PLANNING CONSULTATION RESPONSE

Application No	2026/0045
Proposal	2026 0045 Erection of Extension to Existing Detached Garage and Pitched Roof Over Garage Hudroyd House Genn Lane Ward Green
Address	Hudroyd House Genn Lane Ward Green
Date of Consultation Reply	110226
Consultee	Tony Wiles Senior Conservation Officer

Drawing  
Existing & Proposed Plans, Elevations & Block Plan

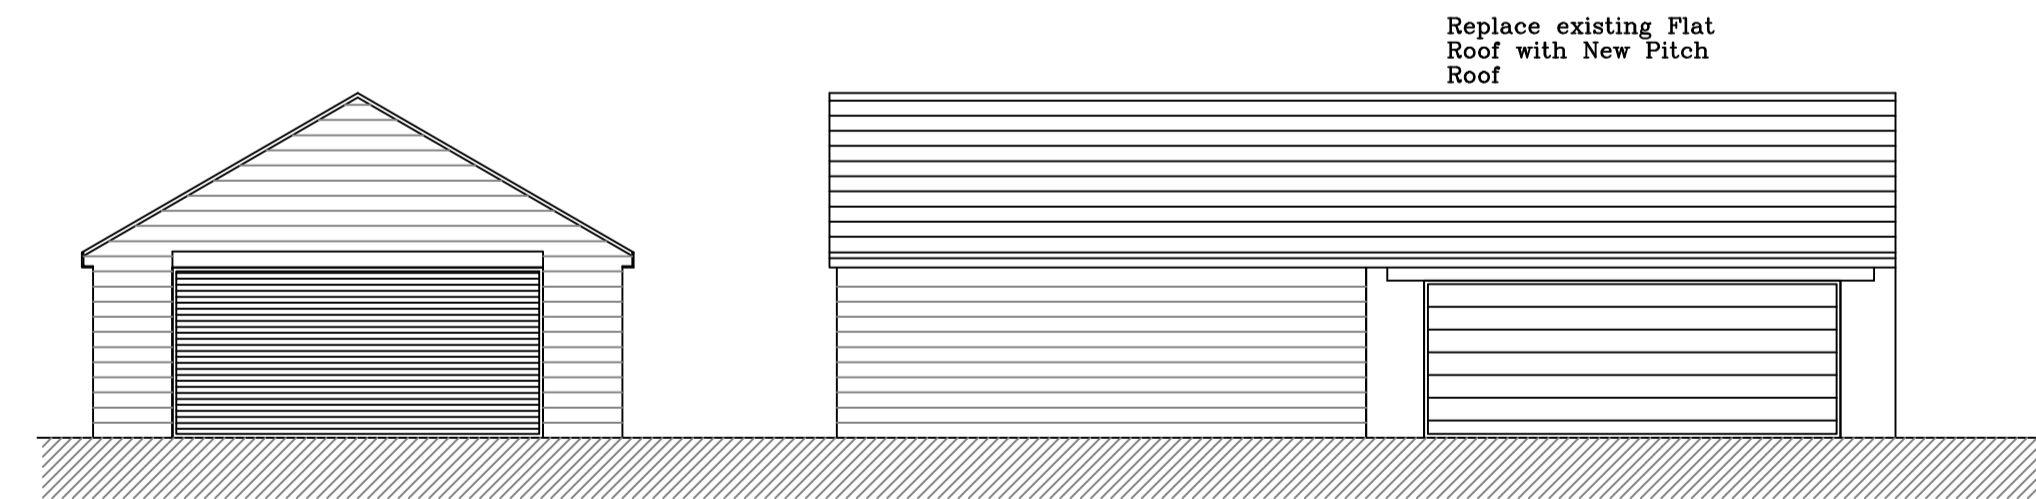
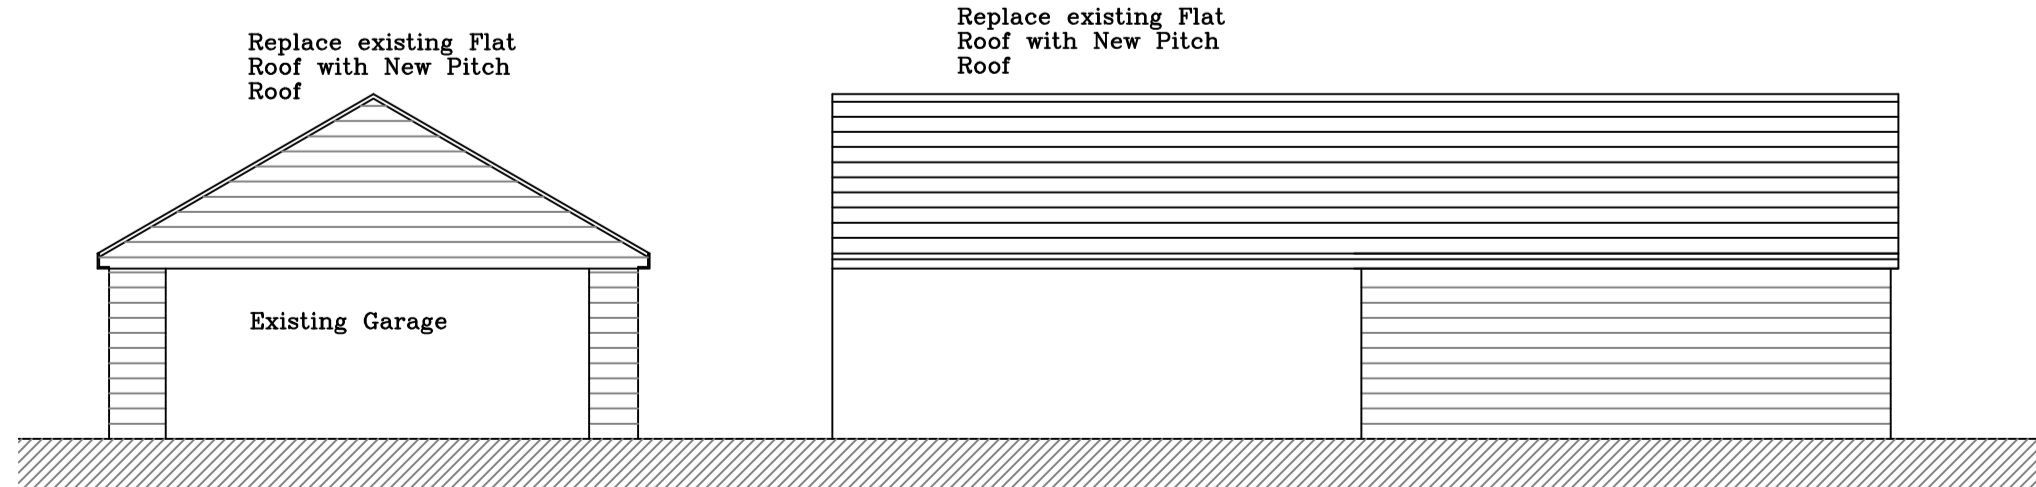
This application appears to be a re-submission of 2016/1547 and 2022/1004 with a very similar proposal; the primary distinction is the installation of a new continuous ridge along the extended pitched roof, omitting the previously depicted step. As previously stated, the existing roadside wall will largely mitigate the visual impact of the development, with the adjacent road providing further separation. The garage's location is notably distant from the host dwelling, resulting in minimal association and reducing the likelihood of cumulative visual intrusion on the setting. Nonetheless, attention should be given to the roof that will remain visible, particularly regarding its materials. Ideally, the roofing should consist of stone, natural blue or grey slate, or high-quality artificial alternatives, as these are the minimum requirements appropriate for the park's setting. Please see suggested condition below.

- The roof shall be covered in either natural stone roofing slates or blue/grey slates or a good quality riven artificial. These shall be laid in diminishing courses with matching ridge tiles.
